Date: 10th March 2020

Our Ref: AL/60/19/DOC

Approval of details reserved by condition imposed under ref AL/107/18/PL relating to Condition Nos 7 - landscaping scheme and 8 - landscape management.

Nyton Stable Nyton Road Aldingbourne PO20 3TU

DRAWING NO: 18307-2-103 RevG

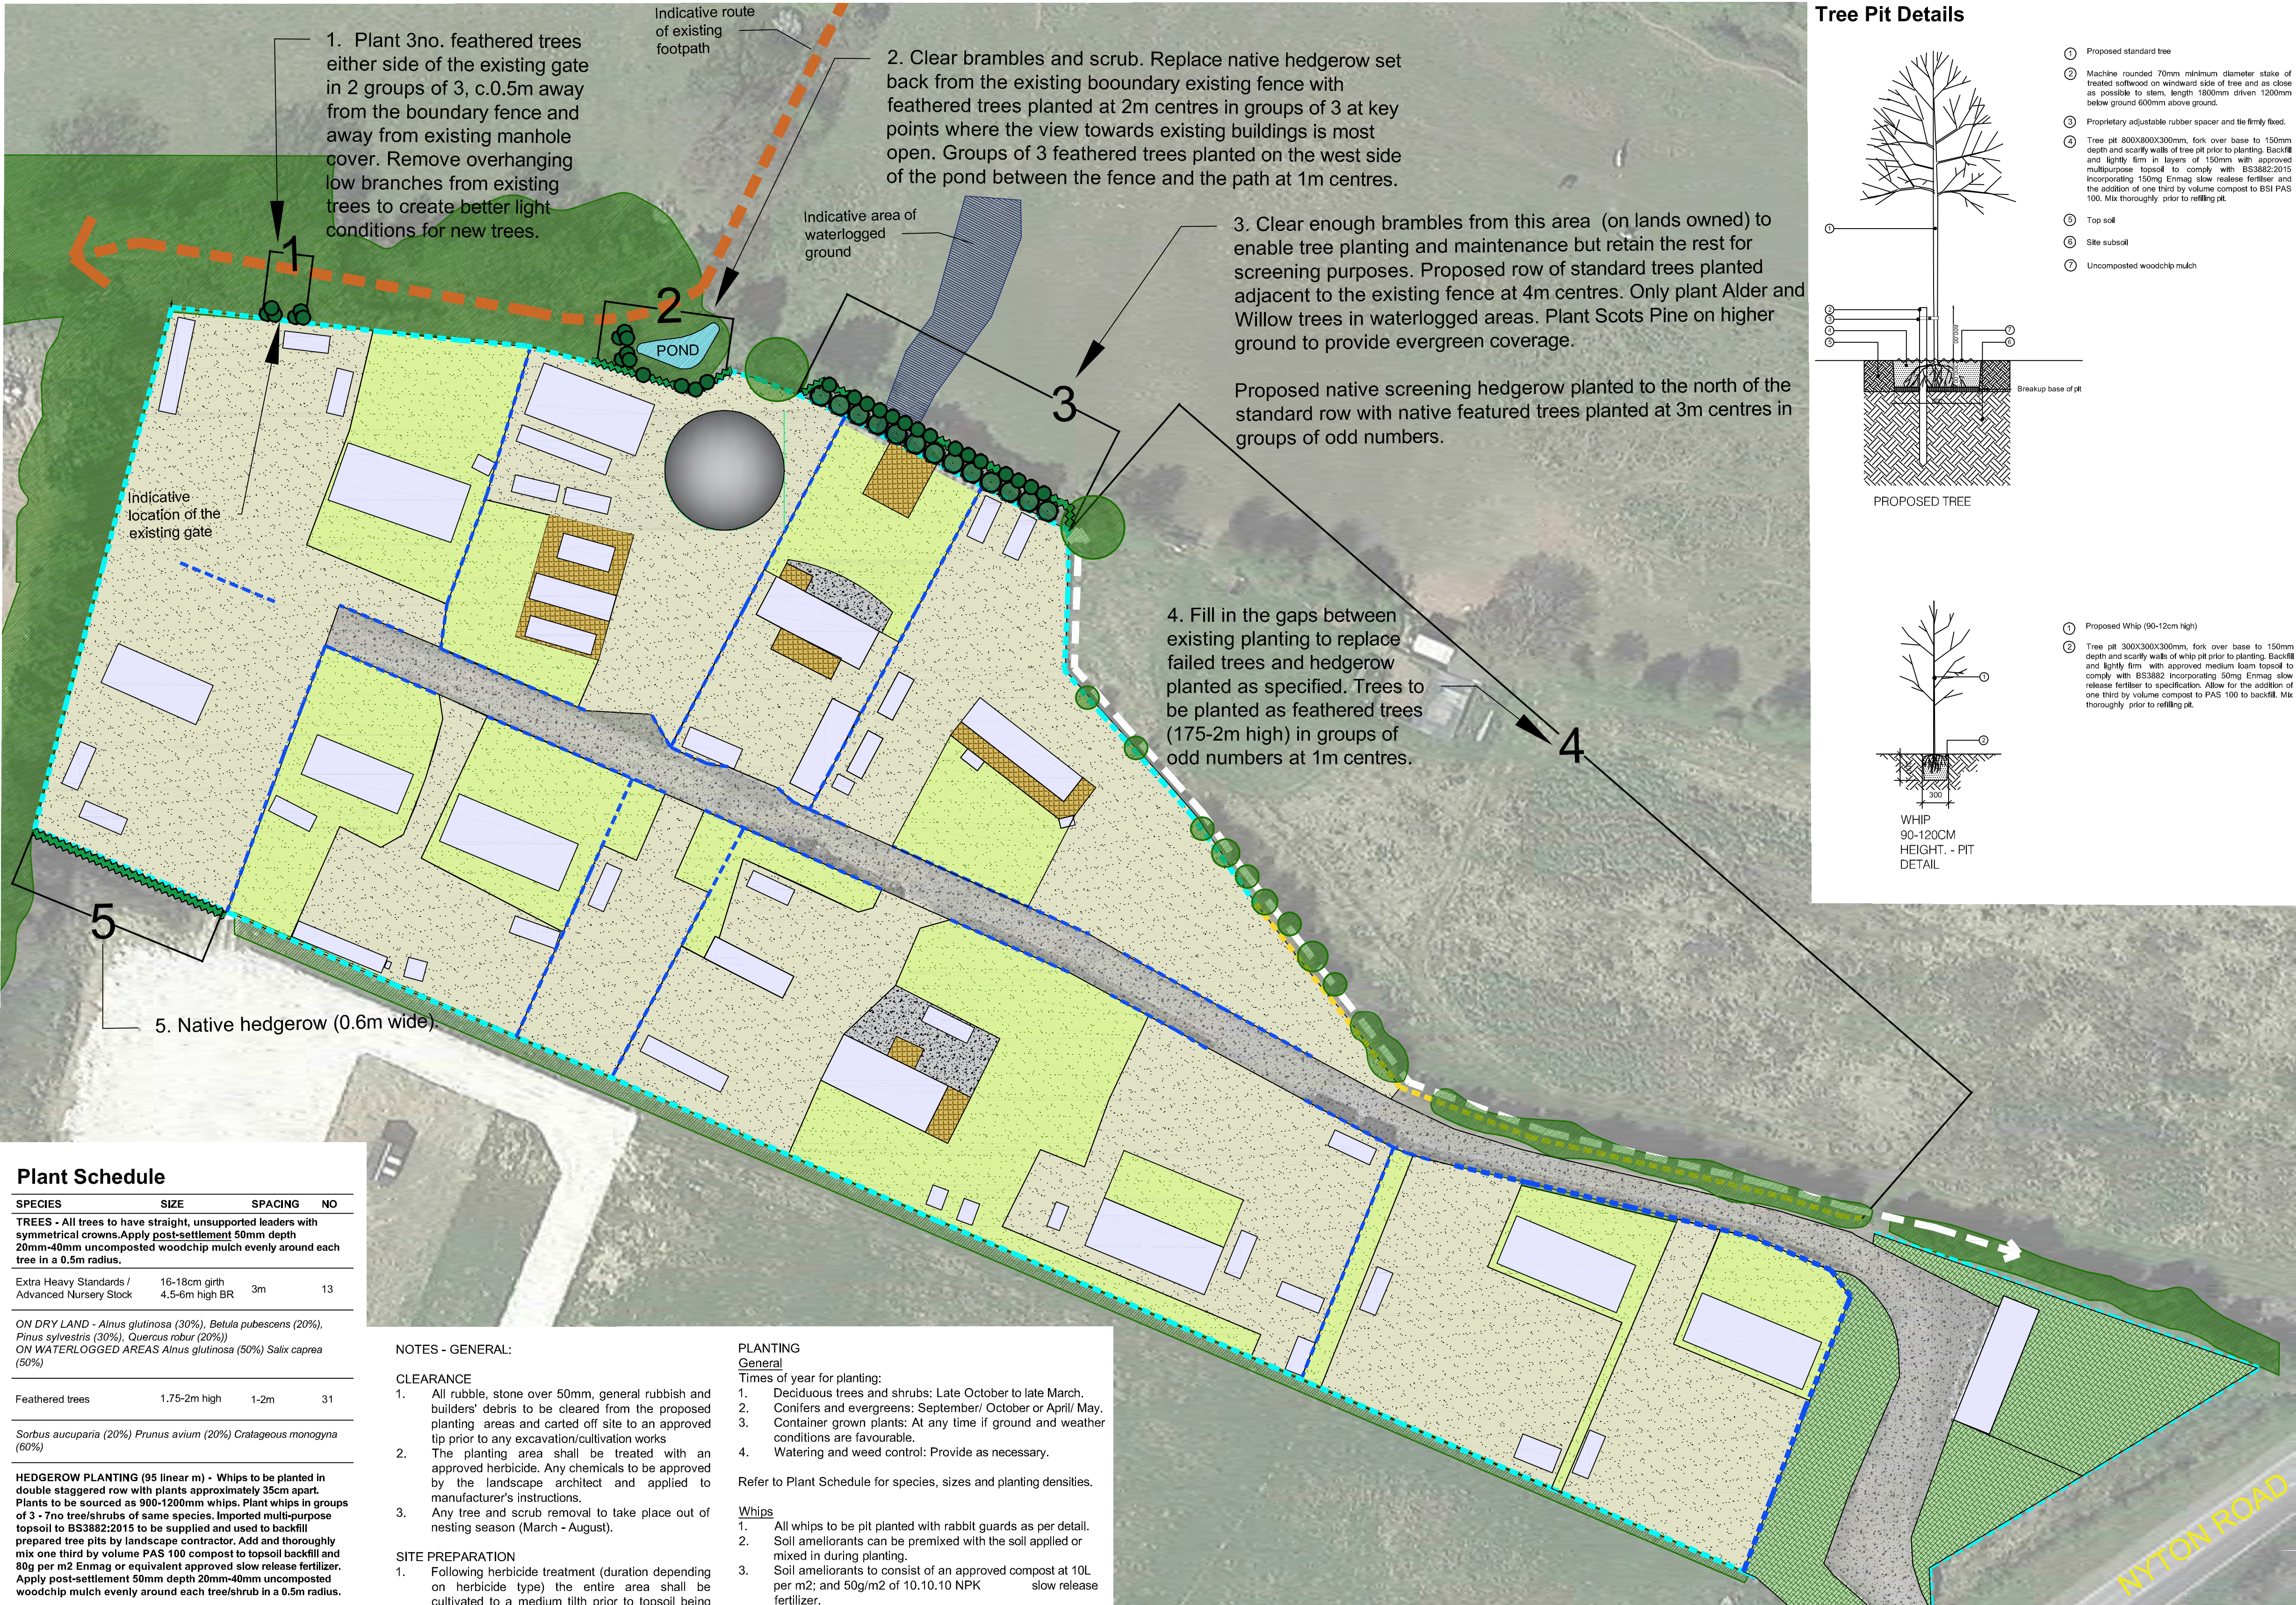
The submitted management and maintenance schedules for all new planting as detailed on the submitted "Landscape Masterplan" drawing 18307-2-103 Rev G now shows the requirement for rabbit guards to the new trees and is thus agreed by the Councils Landscape Officer.

The condition is therefore fully discharged insofar as the submission of details relates and on the understanding that the new trees, hedgerows and other planting will be managed & maintained in accordance with the approved details.
